**KIRKLEES METROPOLITAN COUNCIL  
INVESTMENT & REGENERATION SERVICE**

Reference No:	<b>2025/70/93296/E</b>
Site Address:	101, Shillbank Lane, Mirfield, WF14 0QP
Description:	Variation of conditions 2 (plans) and 3 (materials) on previous permission 2025/90546 for erection of two storey rear extension
Recommending Officer:	Jennifer Booth

**DECISION - REFUSED**

## **OFFICER REPORT**

<b>Planning</b>			
<b>Job No.</b>	MH01-04	<b>Rev.</b>	A
<b>Dwg No.</b>	PL02		
<b>Drawings as Proposed</b>			
<b>Project.</b>	Rear extension to 101 Shillbank Mirfield WF14 0QP		
<b>Client.</b>	Matthew Harrison		
<b>Date:</b>	19.11.24	<b>Scale:</b>	Various@A2
<b>Drawn by:</b>	NA	<b>Checked:</b>	*

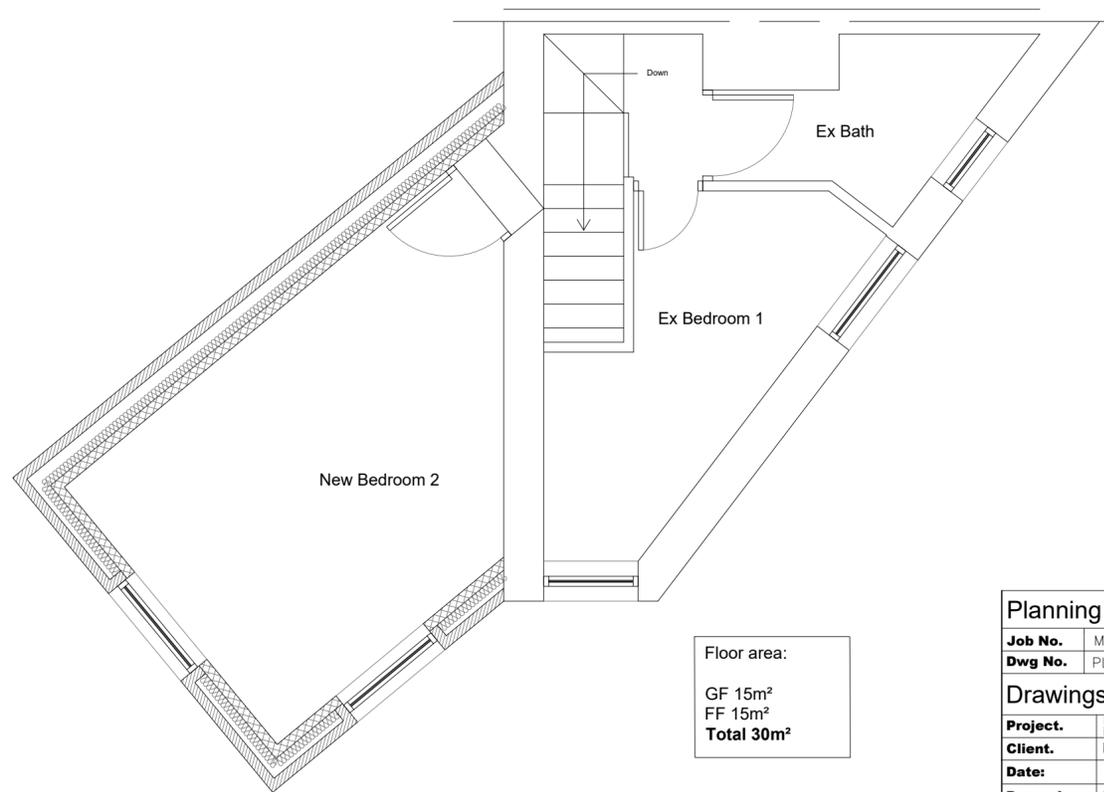
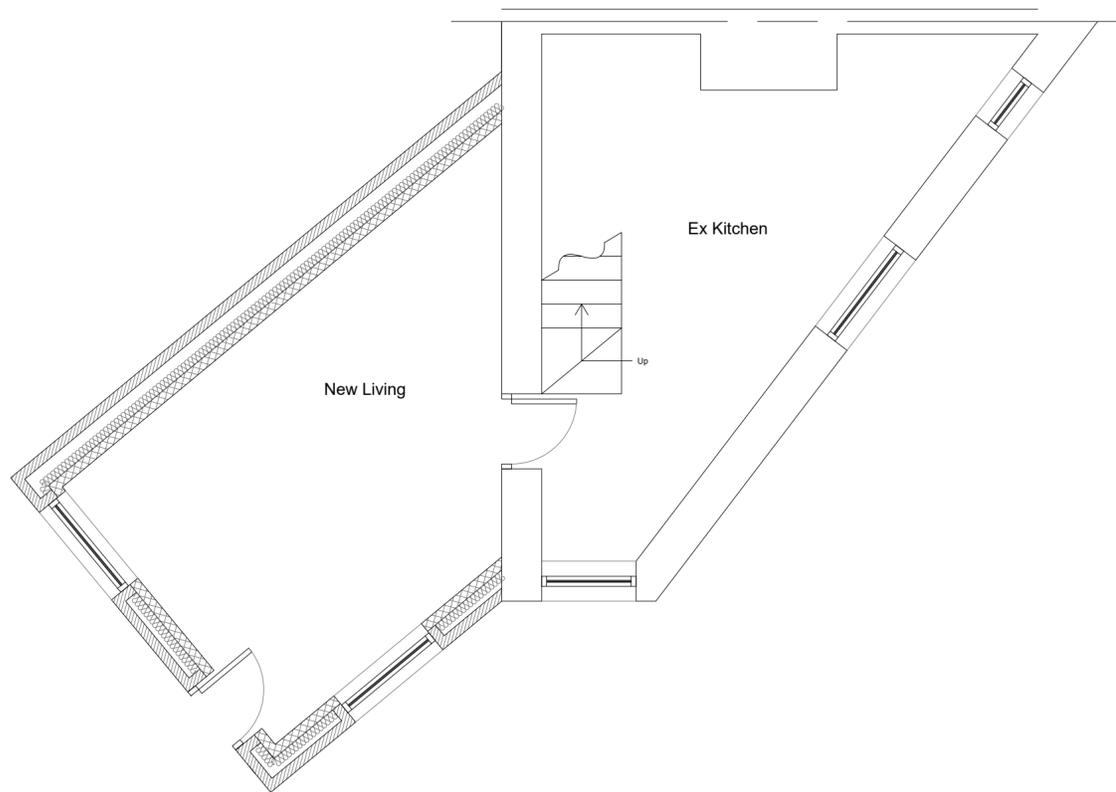
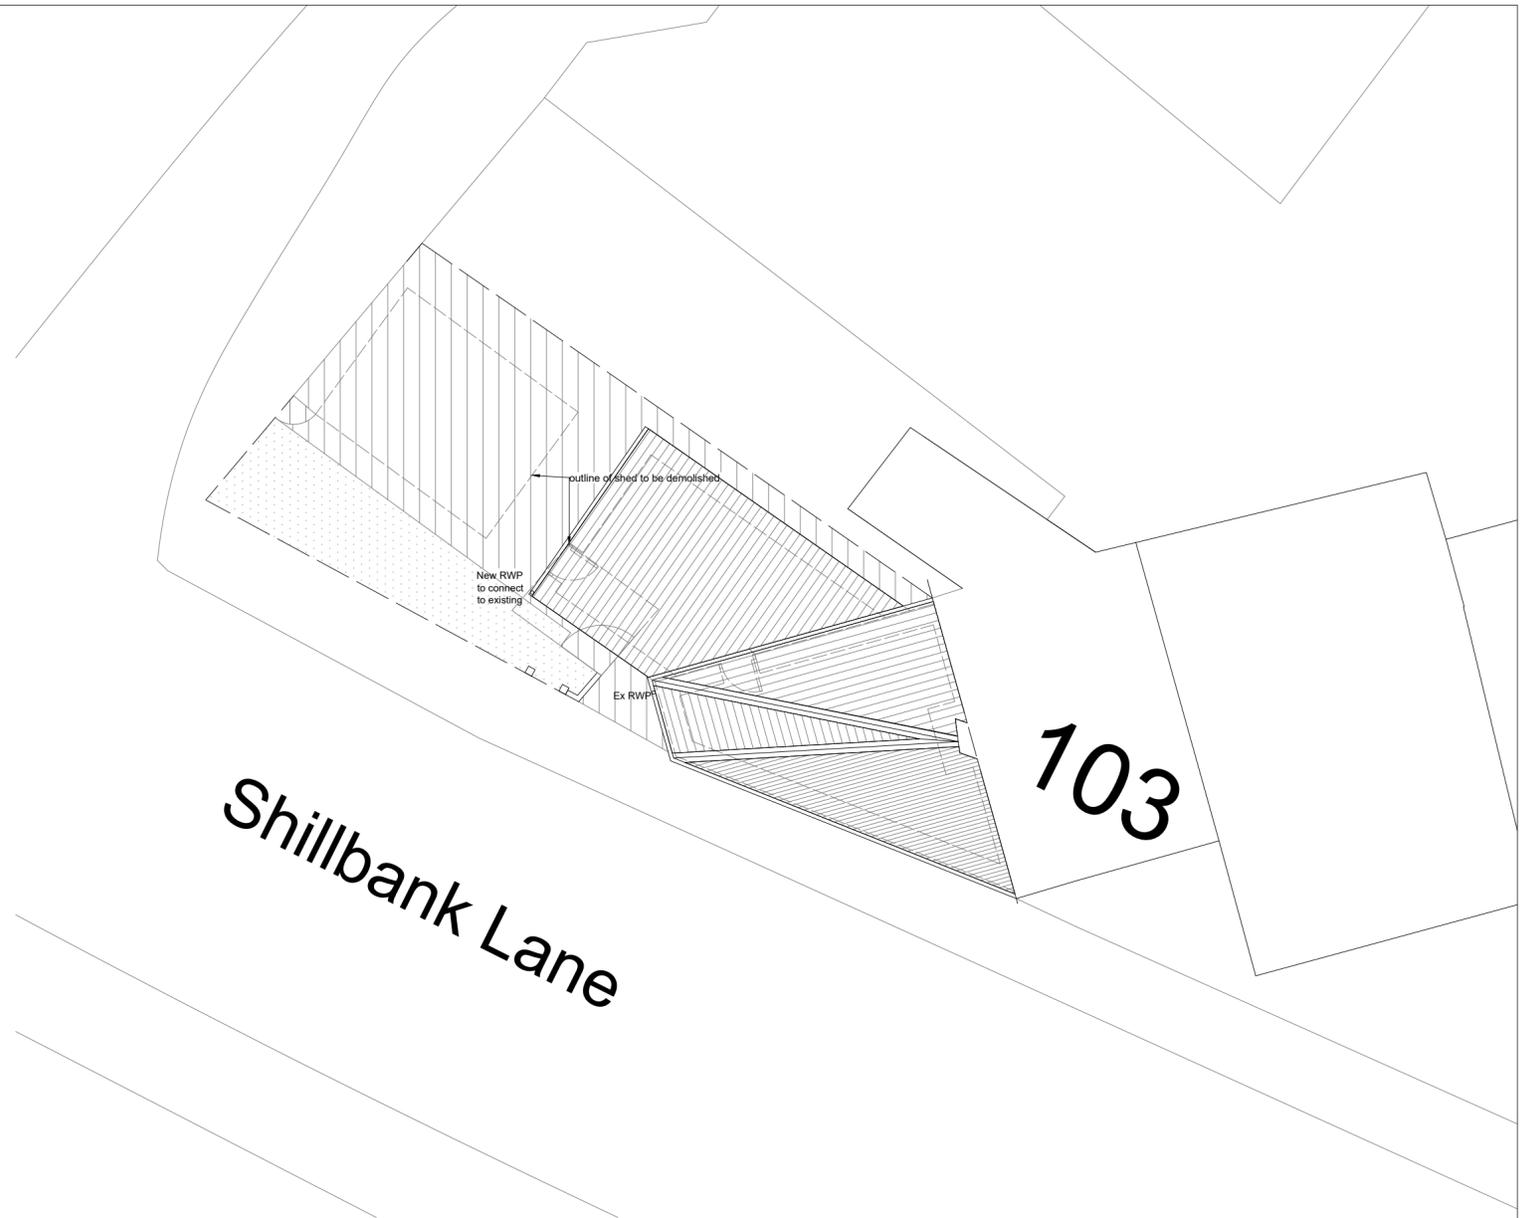
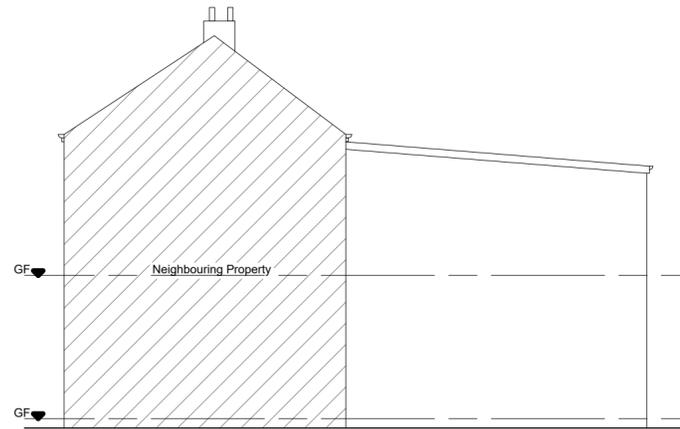
The change includes increasing the projection of the extension from the approved of 3.9m to 6.3m. The front wall would remain stone however the side walls would be constructed using brick.

The proposal seeks permission for a two-storey rear extension. While it is acknowledged that an extension was approved at the site under a previous permission, the current scheme introduces a significantly larger footprint and depth, resulting in a disproportionate addition to the host dwelling. The property is an unusually shaped end-terrace with an obliquely angled rear boundary and garden, which further exacerbates the visual impact of the increased projection. Although the use of stone on the principal elevation, with brick to the remaining walls, is considered broadly acceptable in terms of materials, the overall scale, massing and projection of the extension would appear incongruous when viewed in the context of the host property and surrounding built form. As such, the proposal would cause harm to the visual amenity of the dwelling and the wider area and is considered unacceptable.

Whilst it is acknowledged that planning permission was previously granted for a rear extension at the property, that approval related to a modest projection, only marginally exceeding the depth of the neighbouring property's existing extension and considered acceptable in the specific context of the site. In contrast, the current proposal seeks to almost double the projection beyond that previously approved. Given the very unusual relationship and oblique alignment between the adjoining properties, this increased depth would materially intensify the perceived scale and bulk of the development. As a result, the proposal would result in an unacceptable overbearing impact and would give rise to overshadowing of the neighbouring property and its amenity space, particularly during the late afternoon. Whilst the positioning of the proposed windows is such that there would be no significant loss of privacy, this does not outweigh the overall harm arising from the excessive projection

The proposed two-storey rear extension, by reason of its excessive depth, increased footprint and overall scale, would represent a disproportionate addition to the host dwelling. The current proposal would, when viewed in conjunction with the property's unusual oblique alignment and angled rear boundary, appear overly dominant and visually incongruous. The development would fail to respect the form and proportions of the existing dwelling and surrounding built form, resulting in harm to the visual amenity of the property and the wider area. To permit the proposals would be contrary to Policy LP24 of the Kirklees Local Plan, KDP1 & KDP2 of the House Extensions & Alterations SPD and Chapter 12 of the National Planning Policy Framework.

The proposed rear extension, by reason of the significantly increased projection and massing of the proposed extension, together with the unusually close and angled relationship with the neighbouring property, the development would result in an unacceptable overbearing impact and loss of outlook to the adjoining dwelling. The proposal would also lead to undue overshadowing of the neighbouring property and its rear garden, particularly during the late afternoon. To permit the proposals would be contrary to Policy LP24 of the Kirklees Local Plan, KDP5 & KDP6 of the House Extensions & Alterations SPD and Chapter 12 of the National Planning Policy Framework.
